CITY OF ALBUQUERQUE

October 29, 2020

Re: Sandia Lab FCU
1100 Rio Grande Blvd NW
Traffic Circulation Layout
Engineer's XX-XX-XX (H13-D109)

Based upon the information provided in your submittal received 10-29-2020, the above referenced plan cannot be approved for Building Permit until the following comments are addressed:

ENGINEER'S SEAL RONALD R. BOHANNAN P.E. #7868	RIO GRANDE + 1-40 FULL BUILD OUT	DRAWN BY RG
	TRAFFIC CIRCULATION LAYOUT PLAN	DATE 10-8-2020
	TERRA WEST, LLC 5571 MIDWAY PARK PL NE ALBUQUERQUE, NEW MEXICO 87109 (505) 858-3100 www.tierrawestllc.com	DRAWING 2012100-SP
		SHEET # E3
		JOB # 2012100

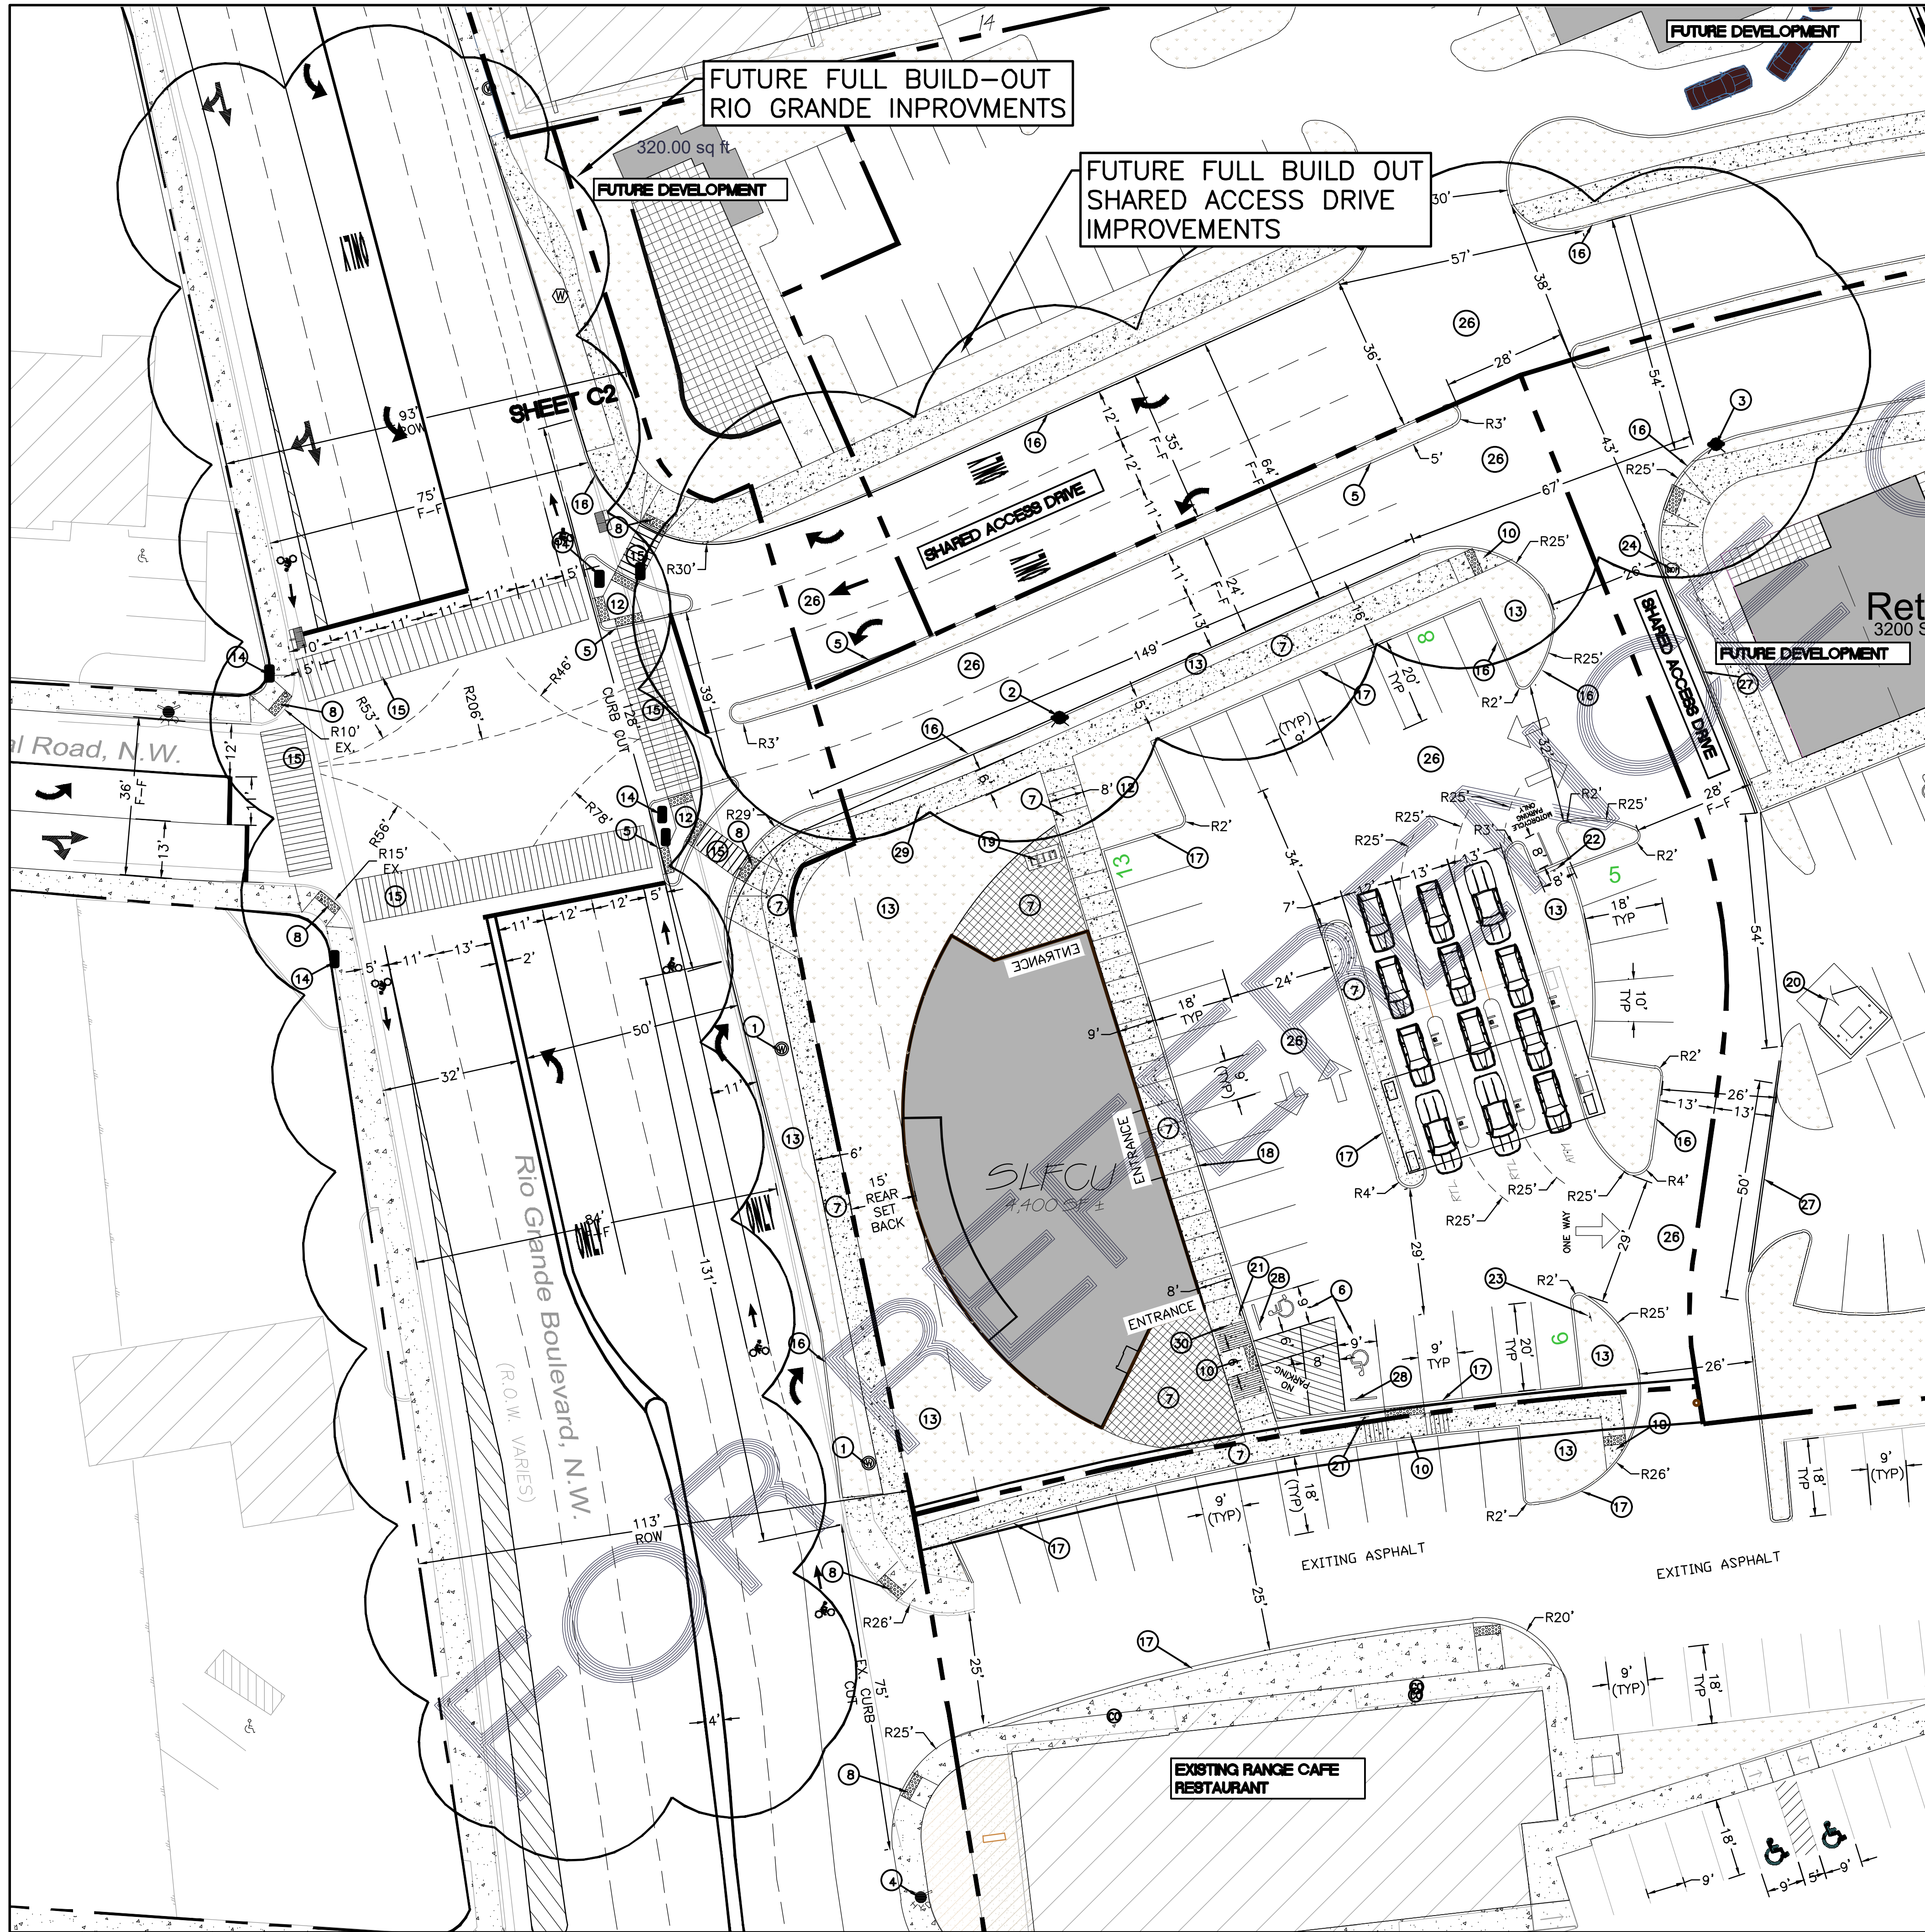
5. Identify the right of way width, medians, curb cuts, and street widths on Rio Grande Blvd and access road.
6. Provide details of all proposed infrastructure and keyed notes within the proposed site plan.

7. Clarify existing property lines and proposed property lines (**Plat status**).
8. Please list the width and length for all existing and proposed parking spaces. Some dimensions are not shown this includes drive aisle.

10. The ADA accessible spaces must include an access aisle. Van accessible aisles should be 8ft wide; all others should be 5ft wide.
11. The ADA accessible parking sign must have the required language per 66-7-352.4C NMSA 1978 **"Violators Are Subject to a Fine and/or Towing."** Please call out detail and location of signs.

12. ADA curb ramps must be updated to current standards and have truncated domes installed.
13. Motorcycle parking spaces shall be designated by its own conspicuously posted upright sign, either free-standing or wall mounted per the zoning code. Label pavement MC.

18. Show all drive aisle widths and radii. Some dimensions are not shown.
19. The minimum drive aisle dimensions are shown:

20. List radii for all curves shown; for passenger vehicles. Radius for delivery trucks, fire trucks, etc. **is 25 ft. or larger.**

21. Per the IDO, a **6 ft. wide ADA accessible pedestrian pathway is required** from the **public sidewalk to the building entrances**. Please clearly show this pathway and provide details.

22. Per DPM, a 6 ft. wide ADA accessible pedestrian pathway is required from the ADA parking stall access aisles to the building entrances. Please clearly show this pathway and provide details.

27. All one-way drives shall have "One Way" and "Do Not Enter" **signage** and **pavement markings**. Please **show detail** and location of **posted signs** and **striping**.

28. The minimum drive through lane width is 12 feet with a 25 foot minimum radius (inside edge) for all turns. (A 15 foot radius can be used with an increase in lane width to 14 feet). Please dimension all lane widths and radii.

29. Please provide a sight distance exhibit
30. Show the clear sight triangle and add the following note to the plan:
"Landscaping and signage will not interfere with clear sight requirements. Therefore, signs, walls, trees, and shrubbery between 3 and 8 feet tall (as measured from the gutter pan) will not be acceptable in the clear sight triangle."
